Reinforcement to the North Shropshire Electricity Distribution Network

Application Reference: EN020021

**SP Manweb's Comments on Responses to the
Examining Authority's First Written Questions**

**May 2019
PINS Reference EN020021**

VIEWPOINT 09: MONTGOMERY CANAL, THE SHROPSHIRE WAY (VIEW SOUTH)

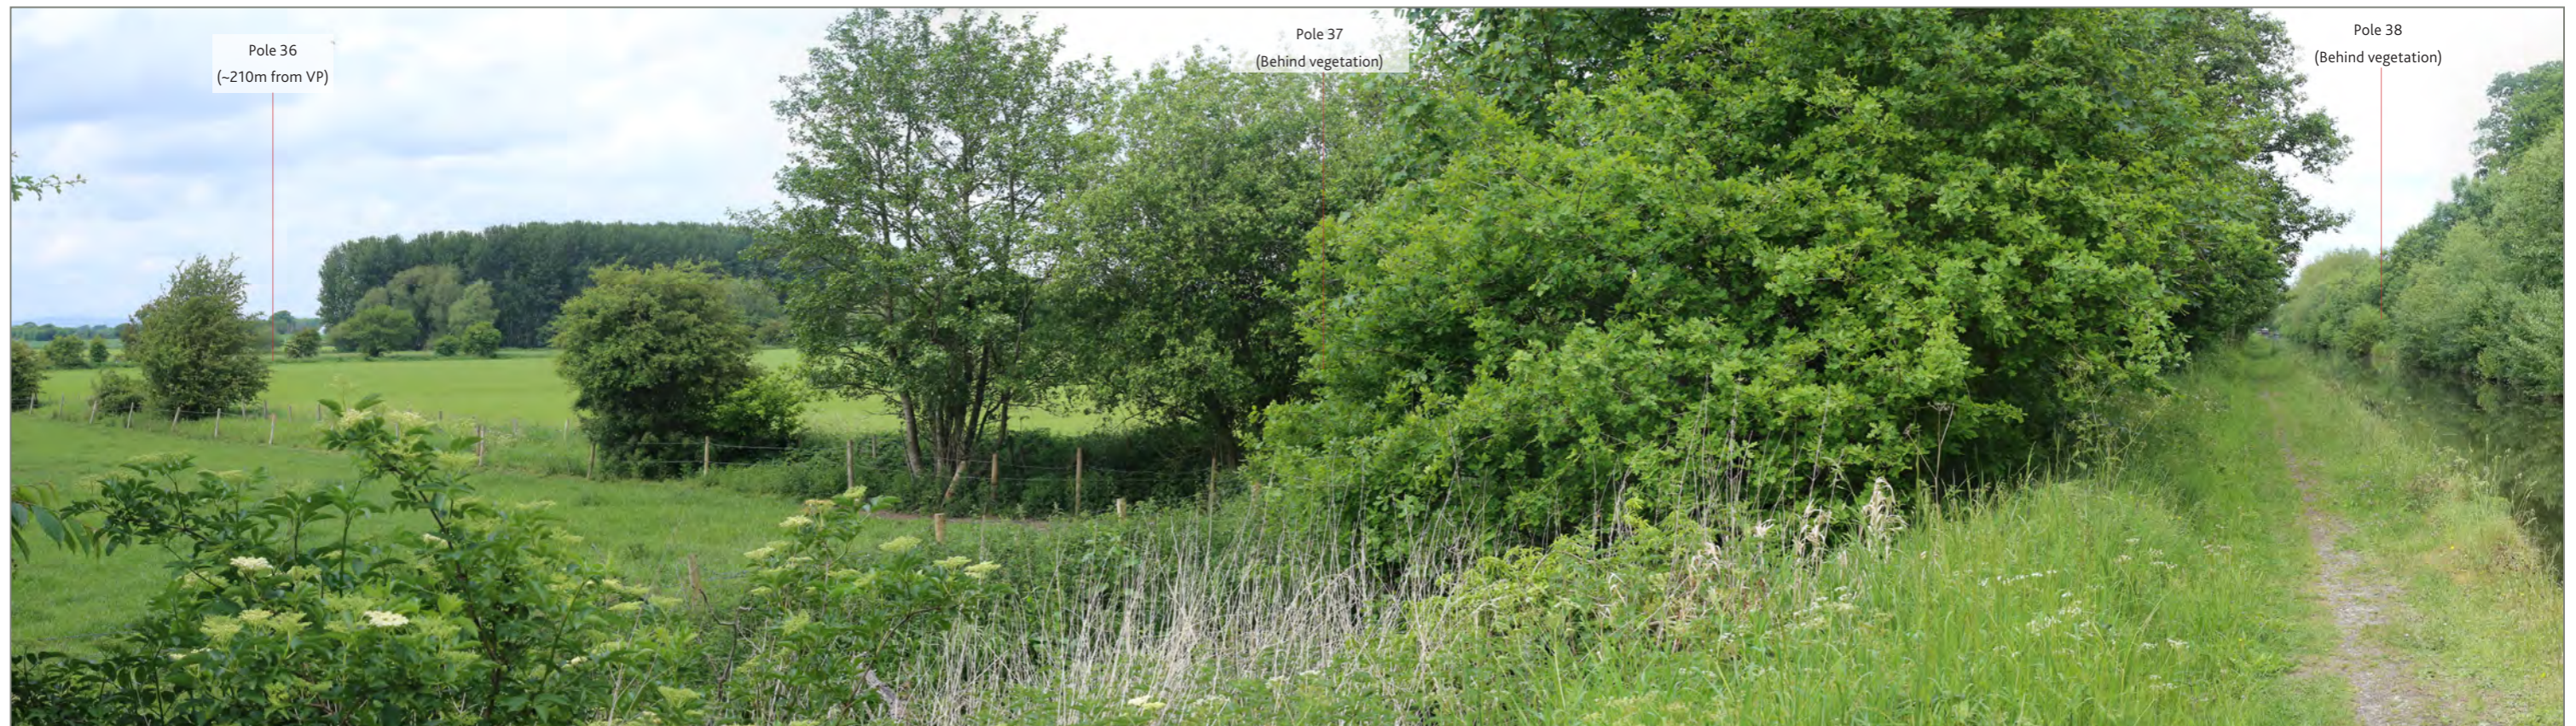
The LVIA document itself is relatively generic and sets out the methodology for assessing impacts. We consider that the methodology used is appropriate. We generally agree the findings of the LVIA in terms of the impact on the canal, insofar that it assesses the overhead line at viewpoints 8, 9 and 10 and assesses the impact from these points as being of 'minor significance'. However, the Trust are unable to agree to the findings of the LVIA in totality, as we would like to see further assessment of the visual impact from underneath the lines where it crosses the canal. As stated at Table A6.3.5 of Appendix 6.3 (page 81), at the point the line oversails the canal the magnitude of change would be medium and effects on visual amenity moderate adverse (i.e. significant). We consider that this justifies a further viewpoint/photomontage being provided from underneath the lines where it crosses the canal. This would enable a full assessment of the impact to be undertaken and for the required mitigation to be identified. This in turn may require the viewpoint to be considered amongst the sites assessed at Table 6.4 of the LVIA and conclusions of the LVIA at paragraph 6.9.3.

2.18. In addition, this section of the Montgomery Canal is very well supported by 3 viewpoints. These viewpoints are located along a 1km section of the canal close to the Proposed Development, and represent views north along the canal tow path, views south along the canal tow path, views into neighbouring fields, and views into Woodhouse Estate from the canal.

Table A7 – Summary of Likely Significant Effects of Underground Connection between Poles 36 and 40

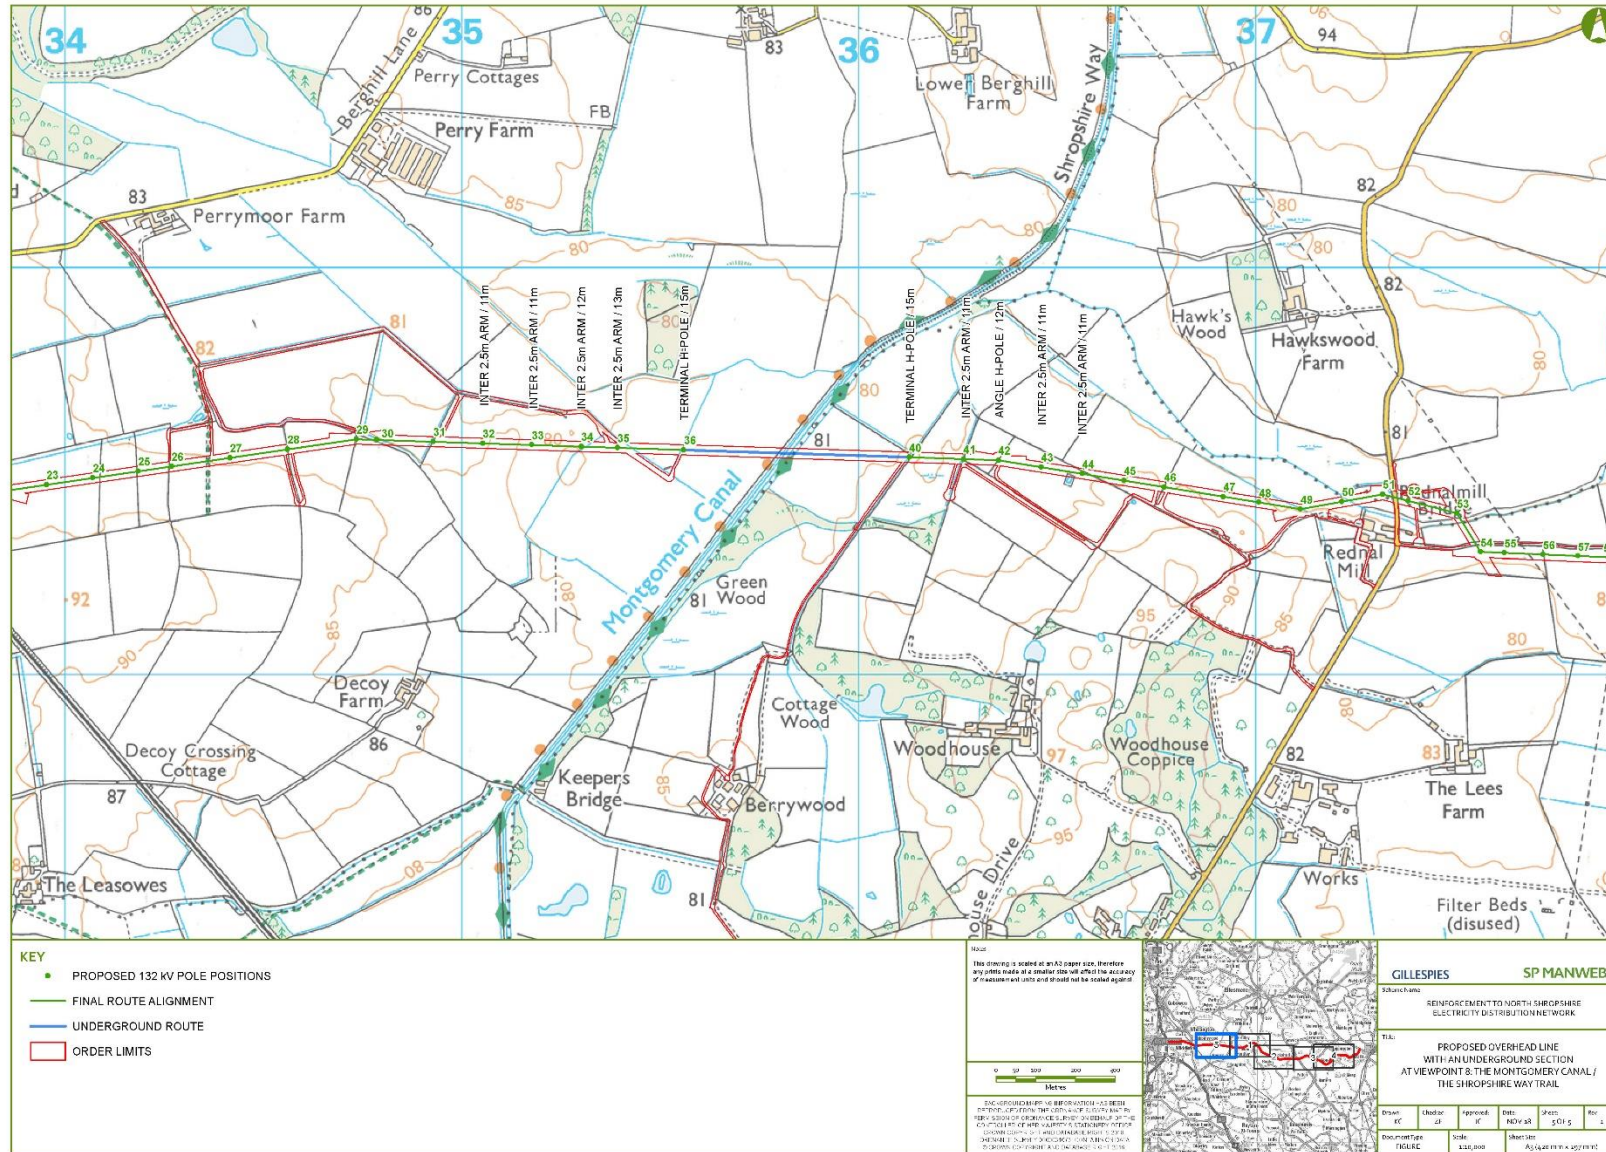
We are still not convinced that the applicants have assessed appropriately the merits of the case for the undergrounding of the line where it crosses the Montgomery Canal. In particular, the information provided in Appendix 1 of the Planning Statement is insufficient and does not provide a cost/benefits analysis as required by paragraphs 2.8.4 and 2.8.9 of the National Policy Statement for Electricity Networks Infrastructure (EN-5). We have today written to the applicant requesting further information....

- 2.3. As the Trust has now recognised, SP Manweb has provided an assessment of undergrounding where the proposed development crosses the Montgomery Canal in Table A7 of Appendix 1 to the Planning Statement (**DCO Document 7.1** (APP-086) (see pages 101-104)).
- 2.4. The analysis of each potential undergrounding option is specifically structured around the factors identified in paragraph 2.8.9 of NPS EN-5 as set out at paragraph 6.1.1, page 83 of Appendix 1 to the Planning Statement.
- 2.5. SP Manweb's general approach, understanding of the policies in relation to undergrounding in NPS EN-5 are set out in sections 2 and 3 of Appendix 1 to the Planning Statement (pages 70-73).
- 2.6. Paragraph 2.8.4 of NPS EN-5 states:

- 2.9. As set out above, it did so specifically, on the basis of paragraph 2.8.9 of NPS EN-5 and in Table A7 expressly considered the costs of undergrounding where the overhead line would cross the Montgomery Canal (£870,000) and the landscape benefits of doing so (some localised benefits) and came to a view on the planning balance that the benefits of undergrounding in this location did not outweigh the dis-benefits.

- 2.11. SP Manweb has gone further than it regards as necessary to address the Trust’s concerns and regards the analysis in Table A7 to be an appropriate and sufficient assessment in particular where the location is not one where policy requires any such assessment at all.
